From: Maria Tomalova <Maria.Tomalova@arun.gov.uk>
Sent: 23 December 2019 11:16
To: Planning.Responses <Planning.Responses@arun.gov.uk>
Subject: FW: Land at Canal Mews Barnham PO22 ODP - Erection of 3 No. Dwellings BN/66/19

Please upload the below to the above application; consultee comments (drainage).

From: Sarah Burrow <Sarah.Burrow@arun.gov.uk>
Sent: 20 November 2019 16:33
To: Maria Tomalova <Maria.Tomalova@arun.gov.uk>
Subject: RE: Land at Canal Mews Barnham PO22 ODP - Erection of 3 No. Dwellings BN/66/19

APPENDIX 5 – Sewage Treatment Plant Details

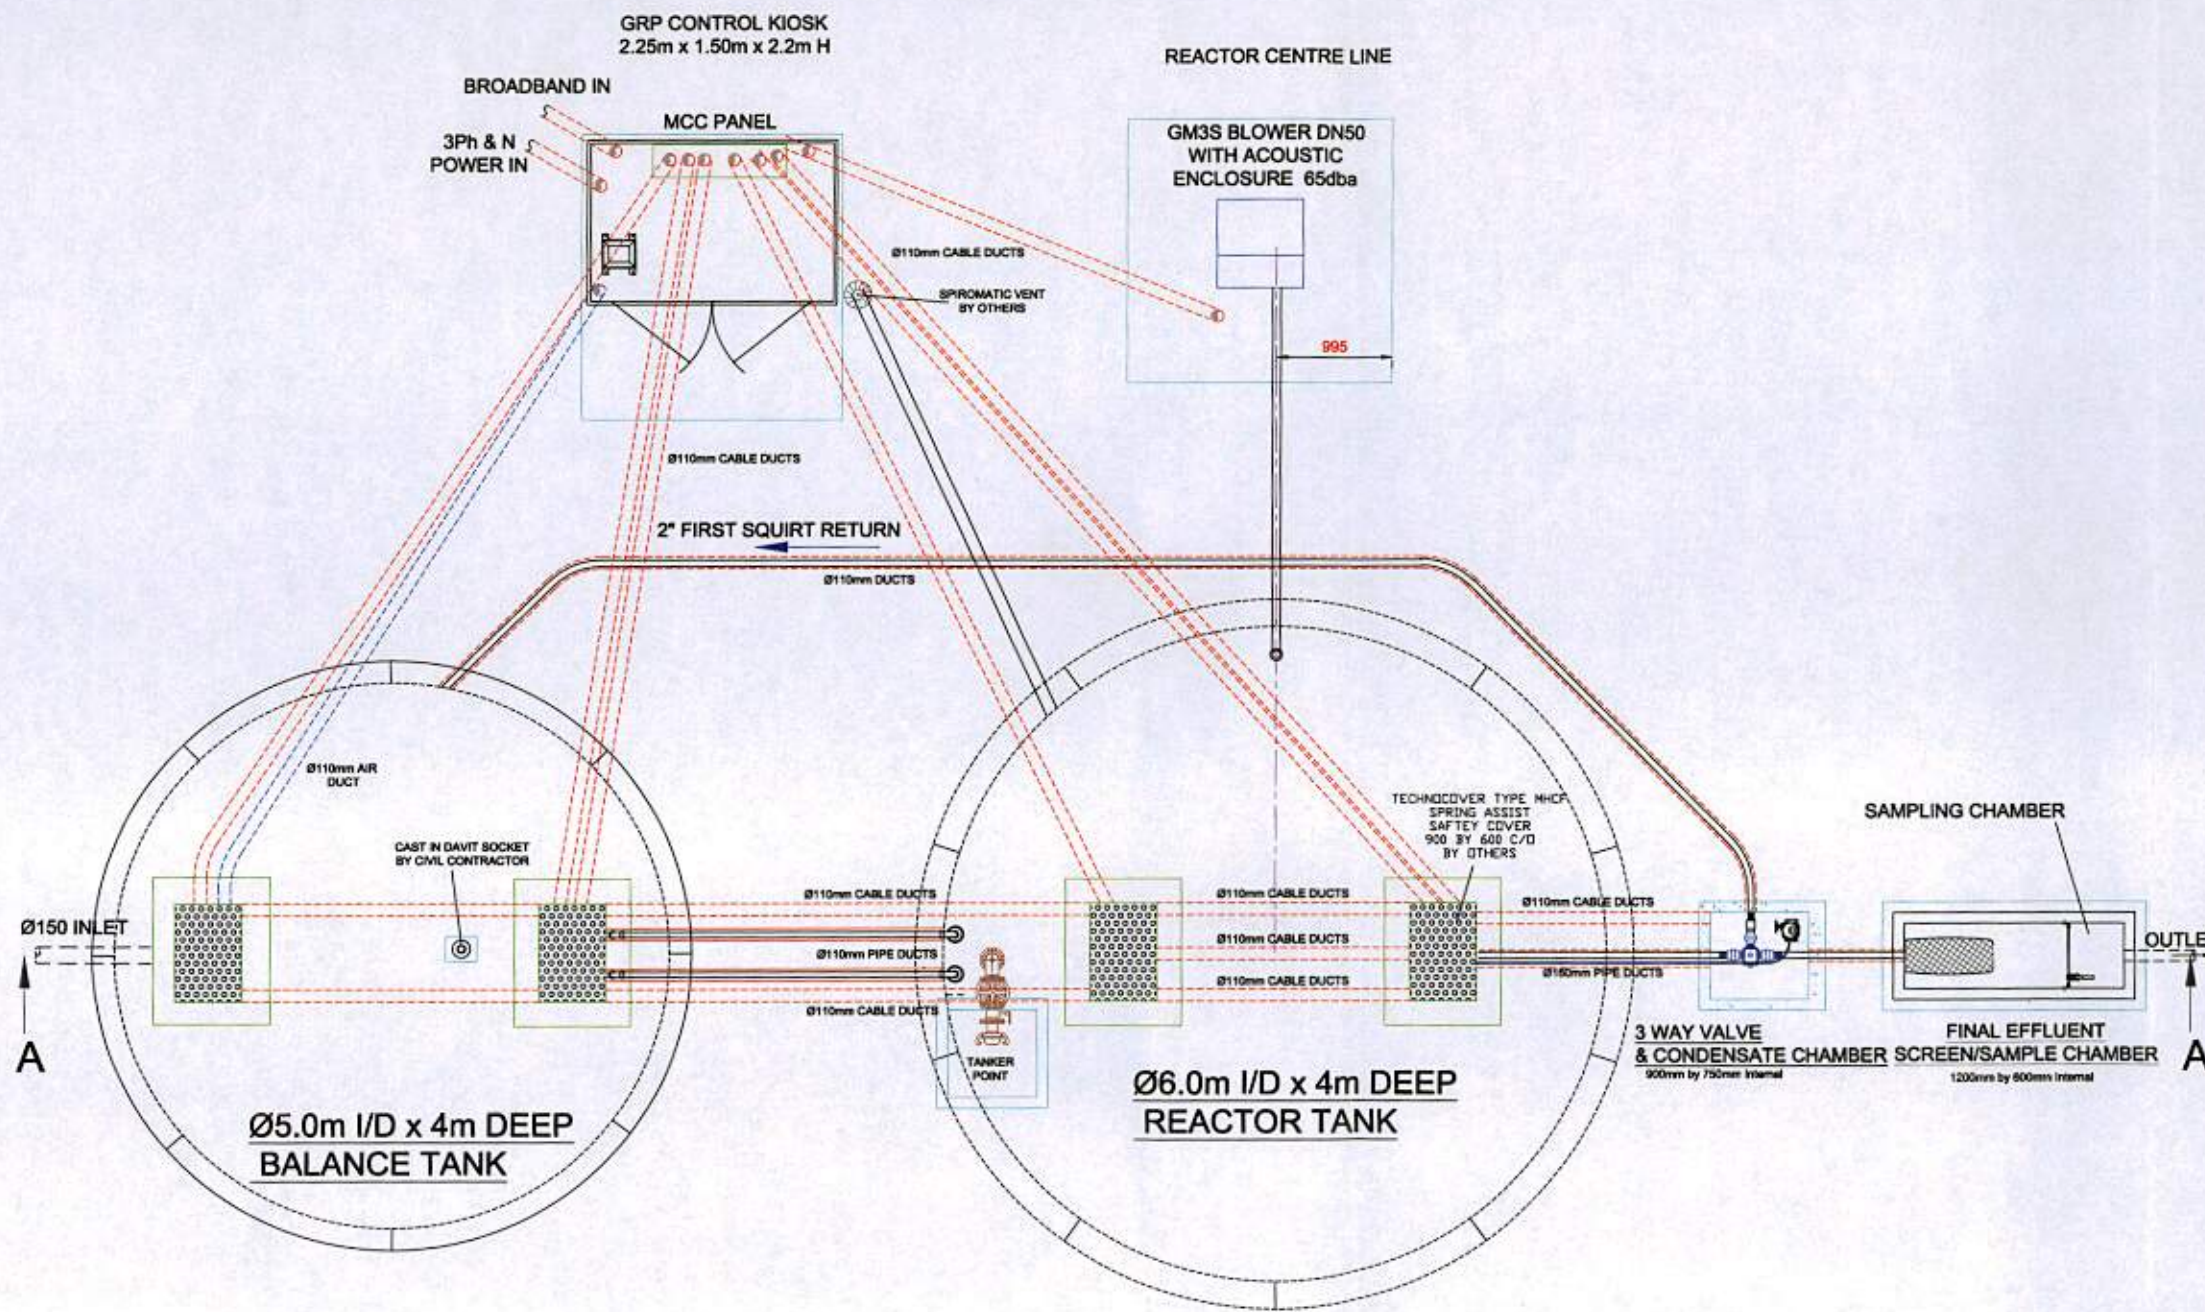
I am confused, the Drainage Statement submitted by Croudace Homes that is referred to in Paul White's letter does not show that there is no treatment plant on the site. I have taken a screen shot of the foul water section – in the statement it is proposed that the treatment plant is used.

Please can the applicant provide evidence to the contrary. Ideally of the agreement between themselves and Southern Water to connect to the main sewer system.
